From: Sarah Burrow <Sarah.Burrow@arun.gov.uk>
Sent: 14 September 2021 09:41
To: Planning.Responses <Planning.Responses@arun.gov.uk>
Cc: Amber Willard <Amber.Willard@arun.gov.uk>
Subject: RE: Planning Consultation on: BE/127/21/OUT

Engineers Comments Regarding Surface Water Drainage

Application No: BE/127/21/OUT
Registered: 6th August 2021
Site Address: 280 Chichester Road Bersted PO21 5AX
Grid Reference: 492305 100723
Description of Works: Outline application with some matters reserved (appearance, landscape and scale) to replace existing single storey bungalow with 2 No. 3 bed dwellings.

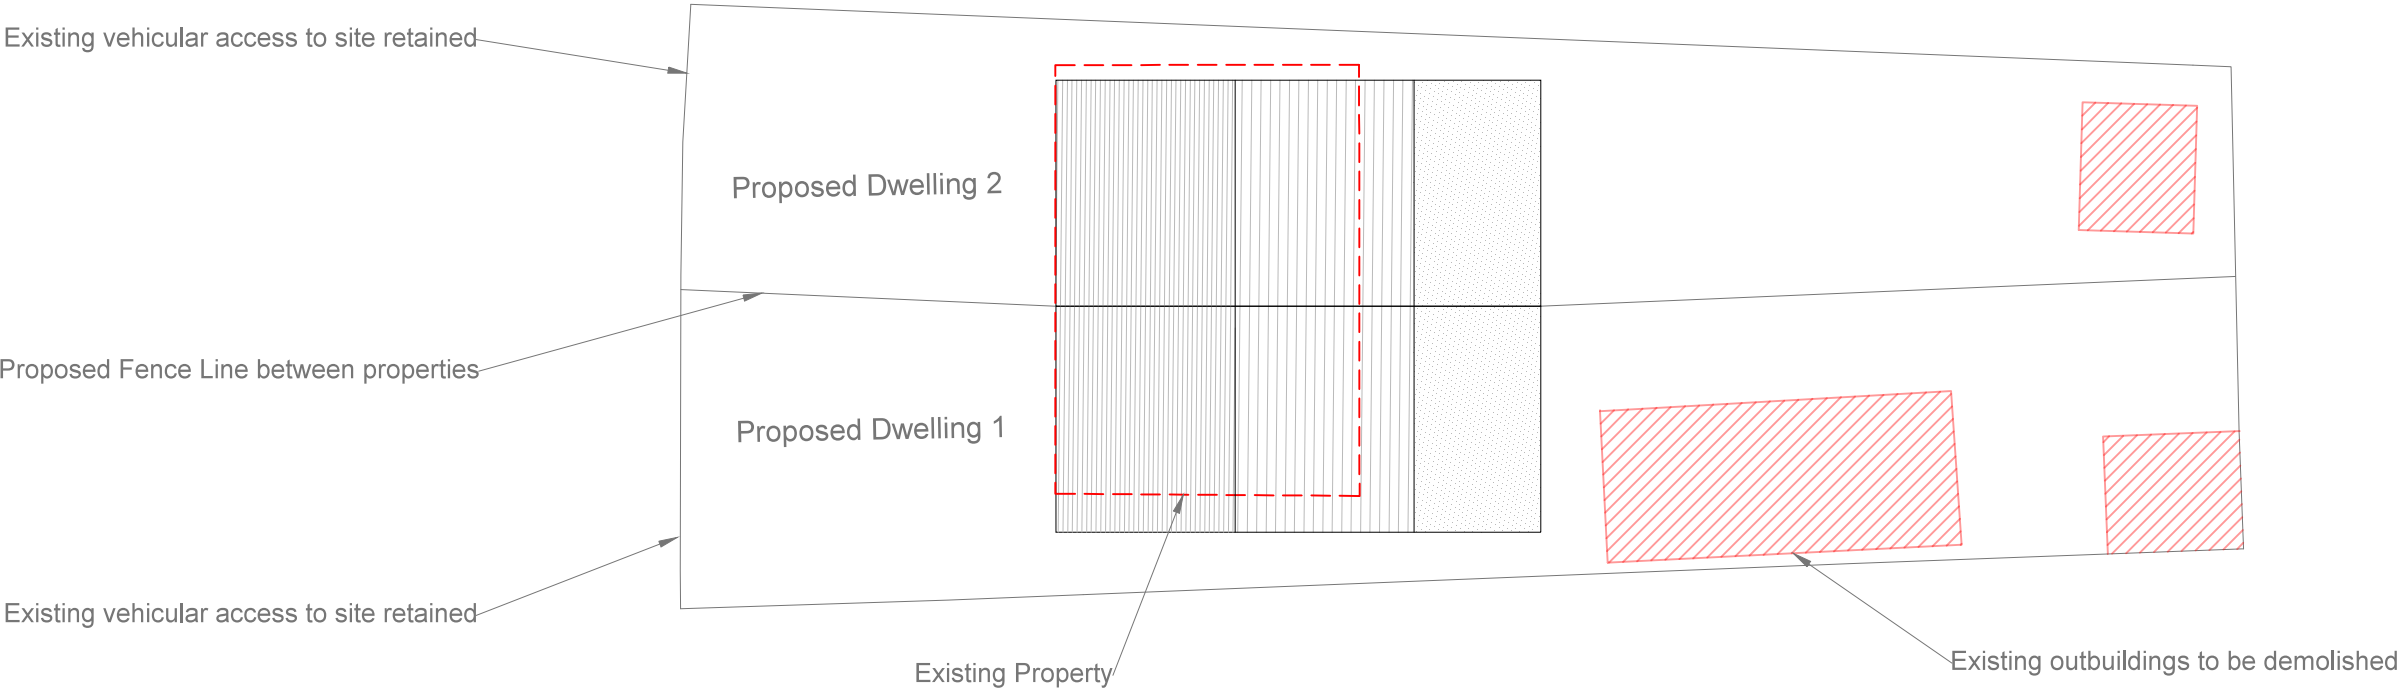
Very little information regarding surface water drainage has been supplied (aside from the suggestion that soakaways will be utilised). There is adequate space on the site to support soakaways should infiltration be viable, we would expect winter infiltration testing and winter groundwater monitoring to support the design of any infiltration system. Existing and proposed trees (root protection zones) must not conflict with suds features/pipework.

If infiltration is found to not be viable then there is a surface water sewer in Chichester Road which can serve as an alternative discharge location. We would not support connection of surface water to this sewer without evidence that infiltration won't work on the site (in accordance with the SUDS hierarchy).

"Development shall not commence, other than works of site survey and investigation, until full details of the proposed surface water drainage scheme have been submitted to and approved in writing by the Local Planning Authority. The design should follow the hierarchy of preference for different types of surface water drainage disposal

systems as set out in Approved Document H of the Building Regulations, and the recommendations of the SuDS Manual produced by CIRIA. Winter groundwater monitoring to establish highest annual ground water levels and winter Percolation testing to BRE 365, or similar approved, will be required to support the design of any Infiltration drainage. No building / No part of the extended building shall be occupied until the complete surface water drainage system serving the property has been implemented in accordance with the agreed details and the details so agreed shall be maintained in good working order in perpetuity."
